Application: 3/2012/0526

**Proposals: Proposed installation of a 15kW Micro Wind Turbine on a 20m
monopole for business use**

Location: Laneside Farm Pendleton Lancashire BB7 1PU

Dr Sarah Manchester
Senior Planning Officer (Ecology)

Plan 3: The Turbine Proposal at the site

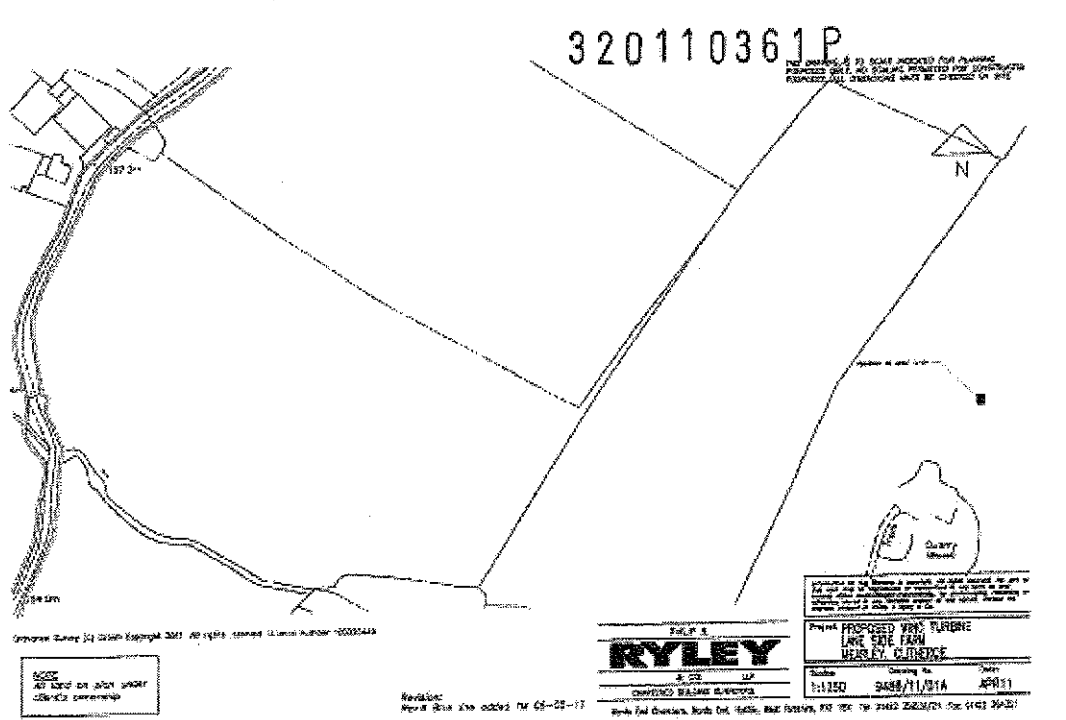
The applicant has submitted the same ecology report (Simply Ecology Limited, September 2011. *Lane at Laneside Farm, nr Clitheroe. Ecological Surveys*) in support of the current application. However, as the proposed turbine location has been amended, the assessment of impacts (and associated recommendations) contained within the ecology report does not relate to the currently proposed turbine location.

The proposed location now appears to be in close proximity to a field boundary. Aerial photographs contained with the ecology report suggest that there may be a hedgerow at this location which may be suitable to be used by bats. As bats are known to be present in this area, it needs to be ensured that the turbine is located to maintain a 50m buffer between the turbine blades and potential bat foraging or commuting habitat. If a 50m buffer cannot be maintained, then the proposals could potentially result in impacts upon bats (killing or injuring) and the proposals would therefore be contrary to the requirements of relevant biodiversity legislation, planning policy or guidance.
